**Making Cycling Better
in Northern Sydney**

BNA/GHF_2101002

Beaches Link EIS – Concerns re Active Transport Impacts on Lower North Shore

Figure A5-8 Active transport impacts within the Gore Hill Freeway and Artarmon area during construction (update to Figure 8-12 of the environmental impact statement and Figure 5-32 of Appendix F (Technical working paper: Traffic and transport))

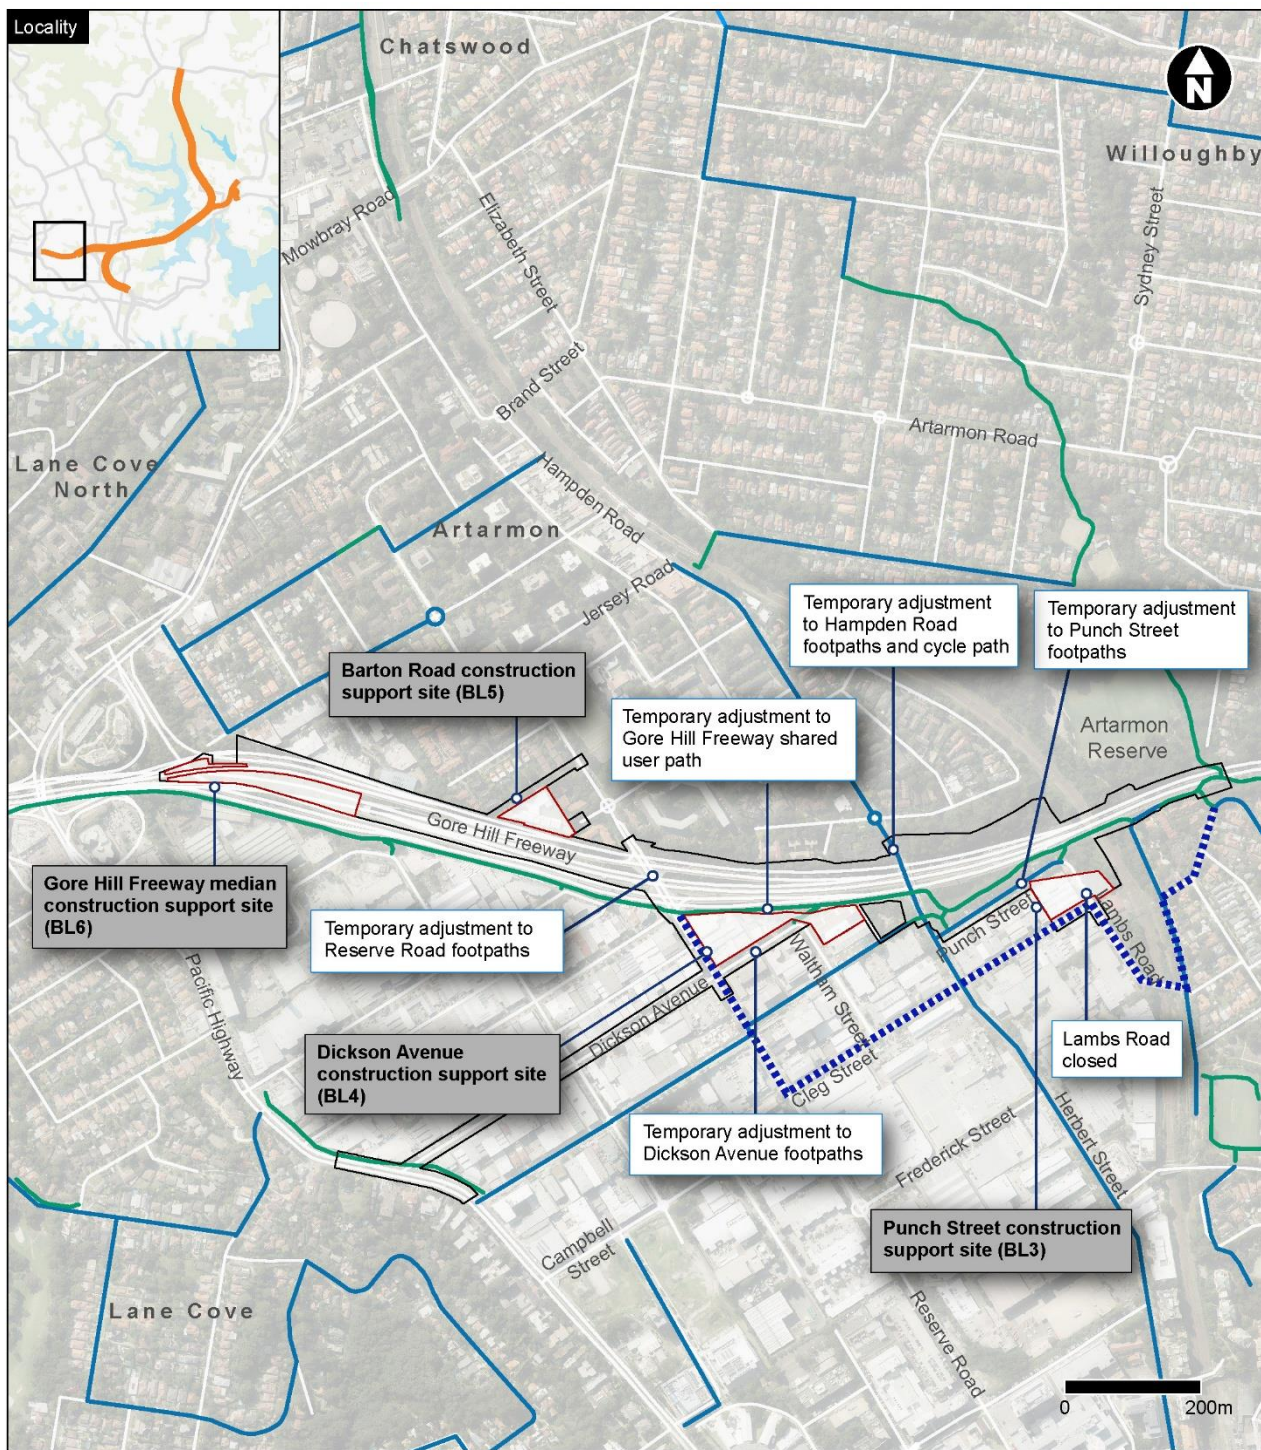
The Beaches Link project team has determined that this pathway will be within their proposed construction zone and that they will therefore need to detour pedestrian and bike rider users of this path between Station Street, Naremburn and Reserve Road, Artarmon for at least the period of four years construction. The EIS document has identified that they propose to detour people walking and cycling, through the hilly and highly trafficked Artarmon Industrial Area, even proposing a route along Reserve Road with its high volume of heavy vehicles and other roads which are access routes to the Beaches Link work sites.

We are deeply concerned that the Beaches Link project team has failed to understand both the high value and importance of the existing path and how inappropriate their detour route proposal is especially considering existing pathway users include families and less confident riders who have been attracted specifically to the traffic free pathway.

Construction will require millions of dollars to be spent to adjust sections of the Gore Hill Freeway to allow cars to continue their usual route during construction. The Beaches Link project team has not given an equivalent consideration of path users to ensure that all ages and all abilities can safely and efficiently continue along the pathway for the duration of construction. Even the temporary ancillary works have been designed before pedestrians and cyclists are considered, leaving the proposed detour unnecessarily long and over hilly and unsafe roads.

The proposed four year detour route includes a hilly climb on local roads in Naremburn, difficult, unsafe manoeuvring into a significant tradie, vehicular route over the railway line at the Lambs

Road Bridge, unsafe mixing with impatient drivers / heavy traffic along Lambs Road and Cleg Street, then extremely unsafe riding along up and downhill on major heavy vehicle Reserve Road. The EIS document itself is contradictory, and lacking in detail. It describes and maps two different routes through the Artarmon Industrial Area. It proposes returning to the pathway at Reserve Road, when there is no existing access. Further questioning of the project team does not give us confidence that they have given the needs of pedestrians and bike riders any consideration in the development of the Beaches Link EIS.

In summary we request that any approval of the proposed Beaches Link ensure that access along the path remains continuous, safe and easy to use. Any necessary detour should be:

- **Minimised to continue along the existing alignment wherever possible.**
- **Provide separation from vehicles, protection from heavy vehicles and to Austroads standards.**
- **Included as part of the overall site design, rather than fitting around a pre-determined site design.**
- **Be based on final designed path as much as practical.**
- **At all times be developed in consultation with Bike North with timely notification of any adjustments.**
- **Provide an underpass of the railway line preferably connecting to Punch Street, so as to avoid steep hills and merging with vehicles on and around railway overpass road**
- **Preferably provide an underpass of Herbert Street**
- **If detoured away from the cycleway, connect directly back to the path from Waltham Street to avoid Reserve Road**
